LU/163/25/PL

Strawberry Field Courtwick Lane Littlehampton BN17 7PD

Amendment to LU/59/24/PL to allow for the formation of overspill car park, rationalisation of existing car park and formation of residents garden including fence panels (resubmission following LU/310/24/PL).

DRAWING NUMBER / TITLE
902 PLANNING - SITE PLAN (PHASE 2)
PROJECT
STRAWBERRY GROVE, LITTLEHAMPTON

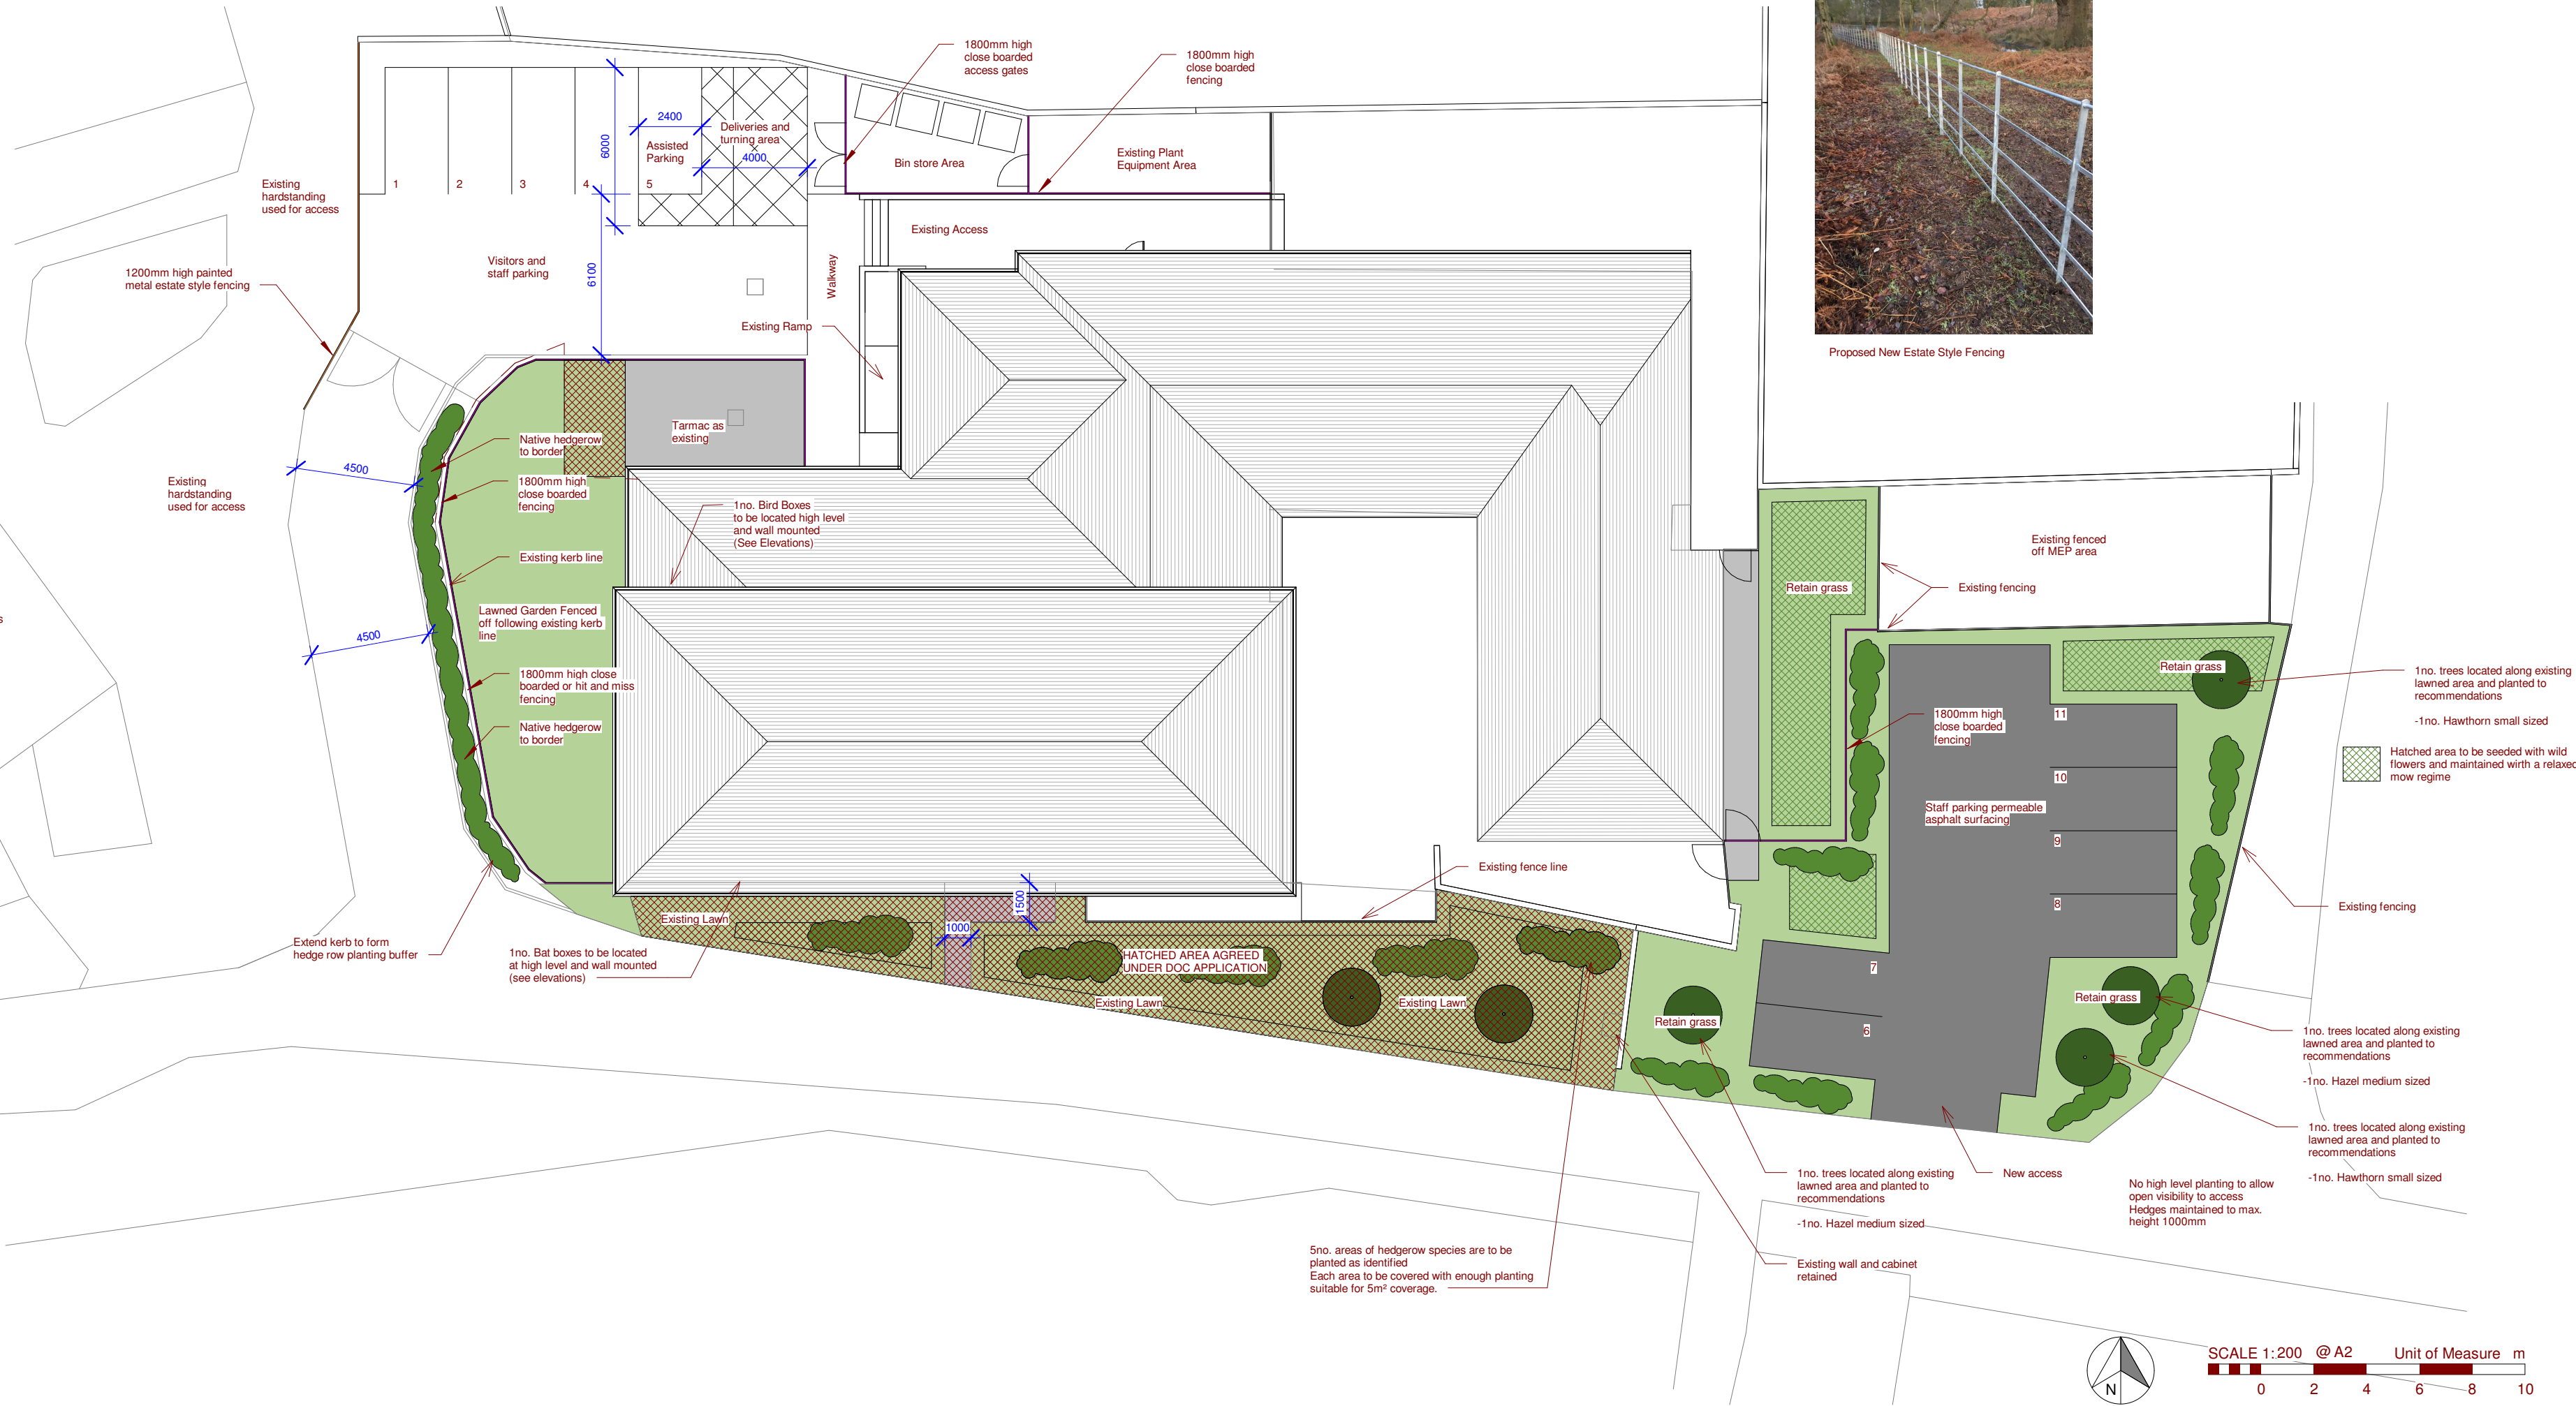
The plans indicate a revised shared access point for both the host building and the neighbouring listed building, which is considered acceptable. The use of estate-style fencing is a positive feature, being more appropriate for this sensitive location. The fencing should be finished in a colour that complements the sensitive context.

While the need for 1.8m fencing to enclose the garden area is understood, it is recommended that the hedgerow be a permanent feature to screen the fencing from view. The fencing should be allowed to weather naturally to a silver tone, rather than being stained.

The proposed staff car park would be introduced into an area currently laid to lawn. This open green space reflects the semi-rural setting of the lane. Although the area is partially enclosed by 1.8m fencing, the open lawn currently provides part of an attractive approach to the site, and to

the listed buildings. The introduction of parked vehicles into this space would result in a visual intrusion, introducing a suburban feature that would not be considered a positive addition to the setting. This impact is exacerbated by the proposed use of asphalt surfacing, which is out of character with the surrounding landscape and the historic context of the site.

It is acknowledged that no additional fencing is proposed, and that supplementary planting is intended to soften the visual impact and help assimilate the car park into its surroundings. This is a positive aspect of the proposal. However, the effectiveness of this mitigation will depend heavily on the quality and coherence of the landscaping scheme. At present, the planting appears to be arbitrarily placed rather than forming part of a designed strategy.

A carefully considered planting scheme will be essential to screen views and reduce the prominence of the car park. It is therefore recommended that a detailed landscaping and planting scheme be submitted for review, and that the Council's Landscape Officer be consulted to assess its suitability.

Clarification is also sought regarding the proposed wildflower planting areas. It is important to ensure that these areas are retained as part of the landscaping strategy and are not subsequently repurposed as overflow parking, which would further erode the character of the site.
